**RE: 1230 ASPEN NW (H13-D33). SUBMITTAL FOR SO #19 PERMIT.
ENGINEER'S STAMP DATED 7-22-96.**

RE: 1230 Aspen, NW (H13-D33)

**RE: 1230 ASPEN NW (H13-D33). SUBMITTAL FOR SO #19 PERMIT.
ENGINEER'S STAMP DATED 7-22-96.**

S.O. 19

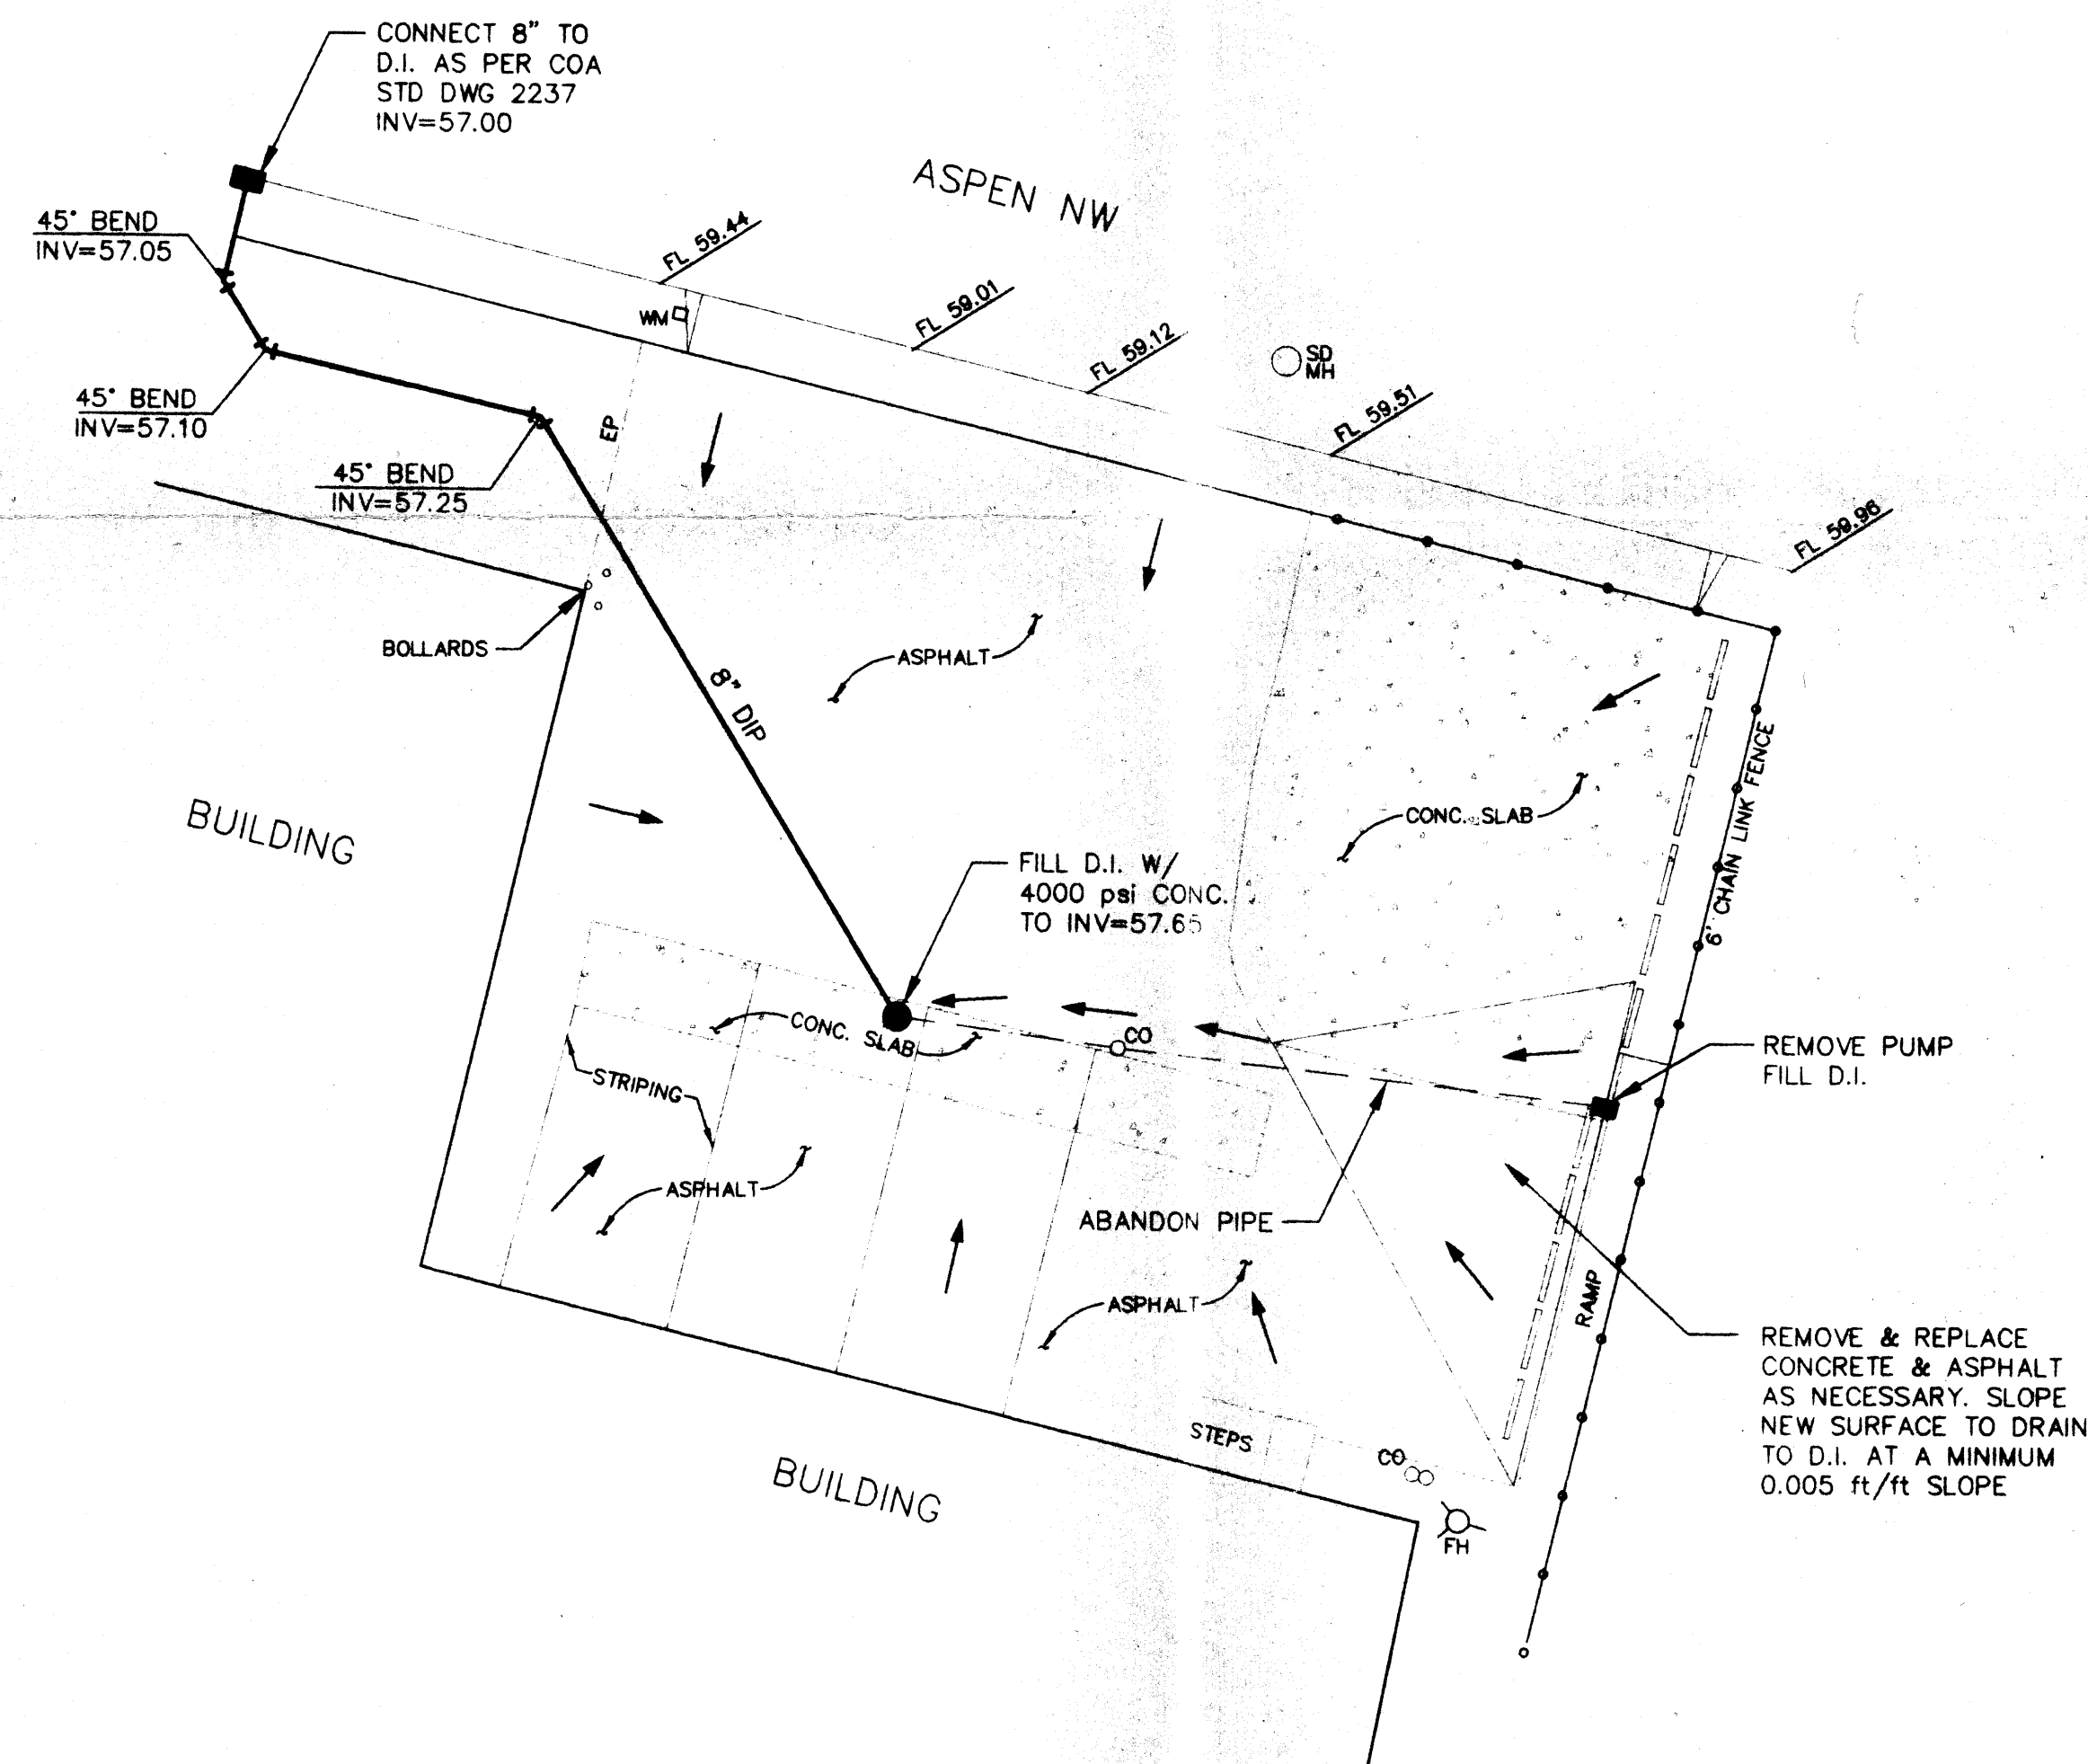
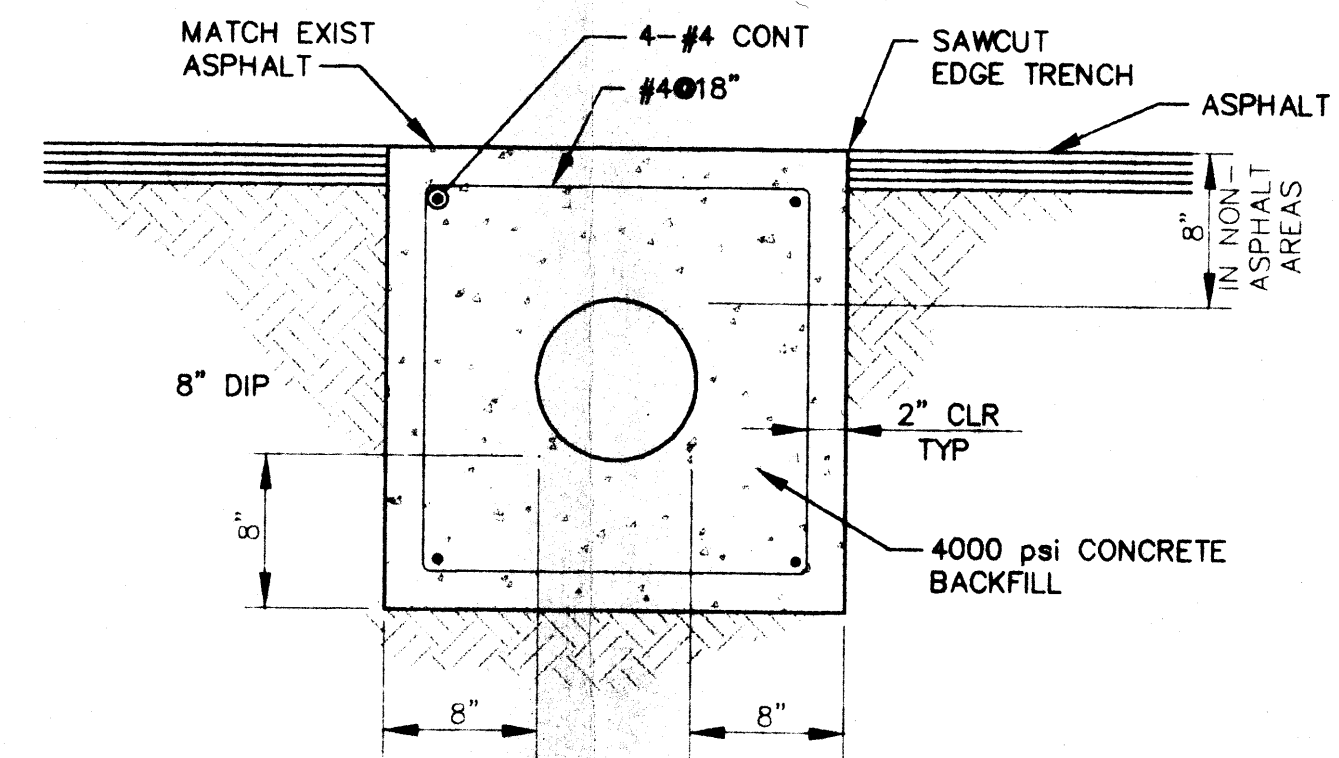
1. I vaguely remember discussing this project with you, however, I do not recall why this property owner wants to tie into the public storm drain system. Please explain.
2. How much flow will be added to the existing storm drain system? Is there capacity for the additional flow?
3. Does the proposed pipe go through adjacent property? If so, an easement will be required.

1. The property currently drains to the sump near the east property line. The runoff is pumped onto the adjacent railroad right-of-way where it puddles and eventually drains to Aspen. The right-of-way is a smelly mess. This project will make a more direct connection to the storm drain in Aspen and eliminate the problems in the right-of-way.
2. The storm drain system is at capacity. Currently the runoff temporarily ponds in the street and on the site. It will continue to do the same in the future.
3. An easement is not necessary since the line remains on one property.
